**East Park Energy**

## **Schedule of Changes to the Draft Development Consent Order**

**Document Reference: EN010141/DR/8.2**

**May 2026**  
Version P04

Dwg no
3149-2.4-002 Rev
P02

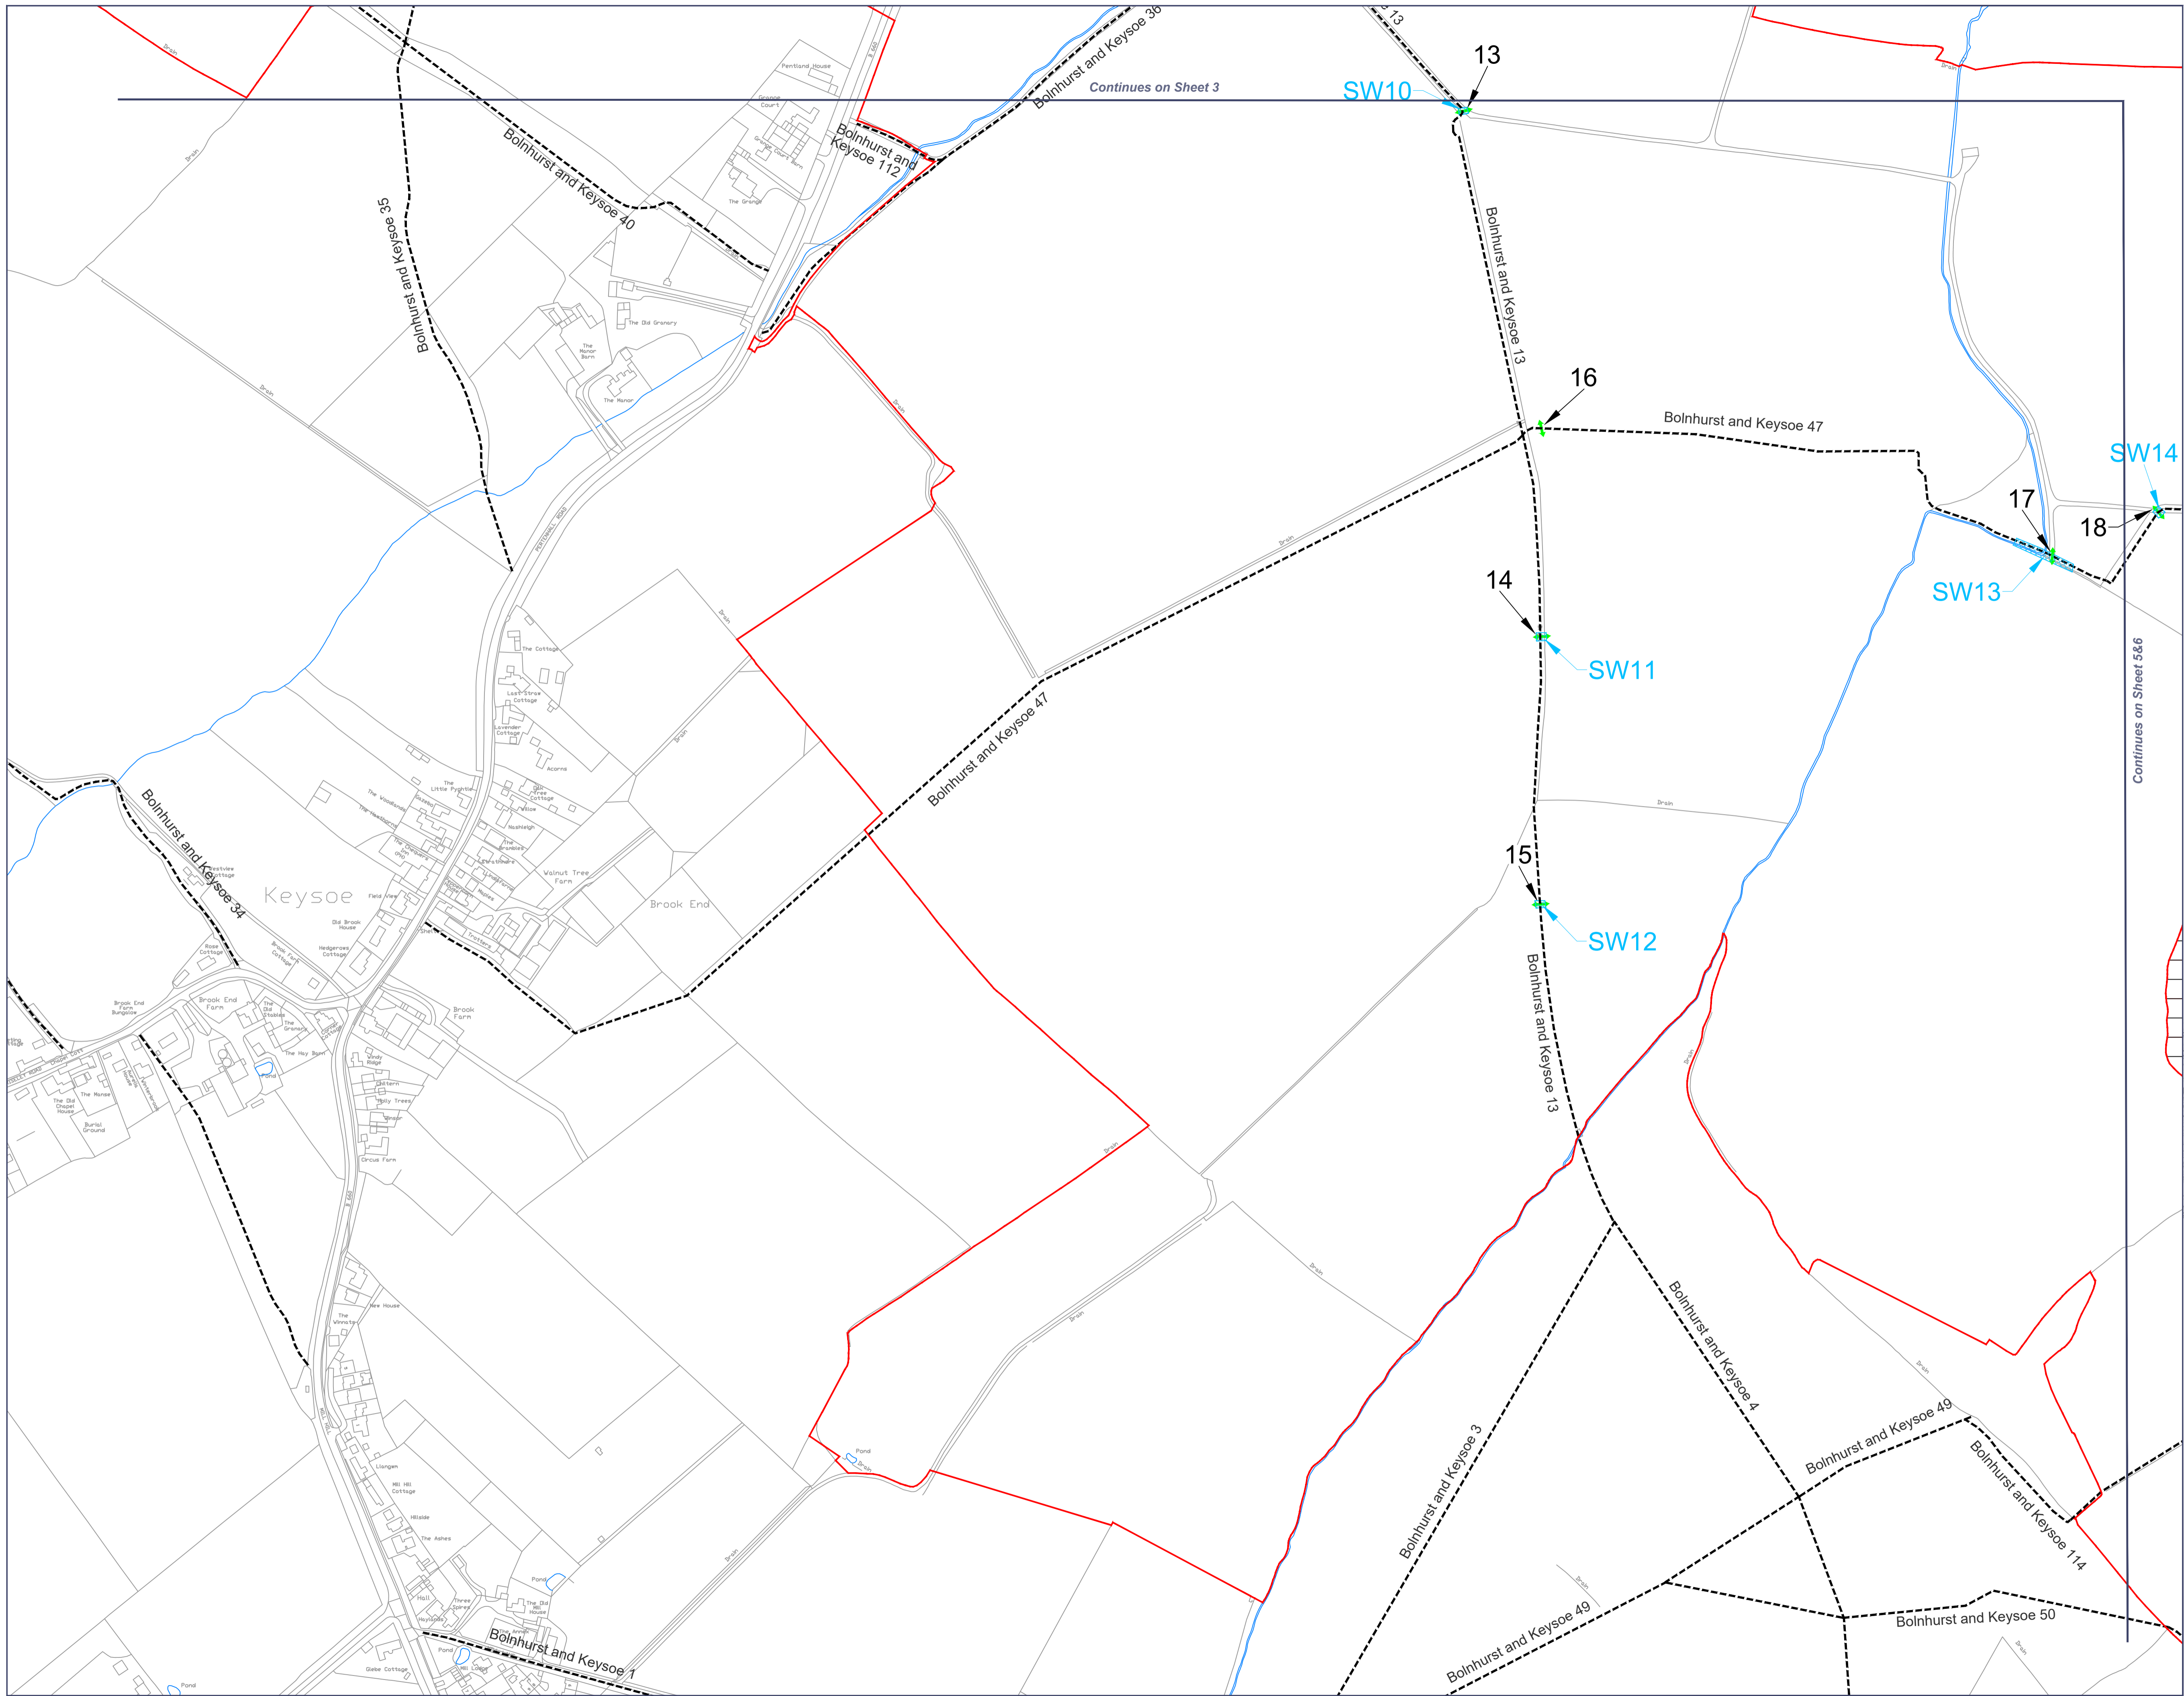
Article / Paragraph / Schedule	Amendment			Reason
	<i>Little Staughton</i>	<i>Green End</i>	<i>Works for the provision of a permanent means of access shown shaded orange on sheets 5 and 6 of the street works, public rights of way and access plans, reference AS-4</i>	works, public rights of way and access plans.
<b>Schedule 6, Part 2, Authorising permanent use of motor vehicles on public rights of way</b>	The table at Part 2 of Schedule 6 has been updated as follows:			Updated to ensure alignment with the street works, public rights of way and access plans.
<i>Bolnhurst and Keysoe</i>	<i>Public Right of Way – Bolnhurst and Keysoe 37 Bridleway</i>	<i>Motor vehicles authorised by the undertaker may pass along or cross the length of the public right of way between the point marked PMV-4 on sheet 3, and the point marked PMV-54 on sheet 2 of the streets, public rights of way and access plans shown shaded blue.</i>
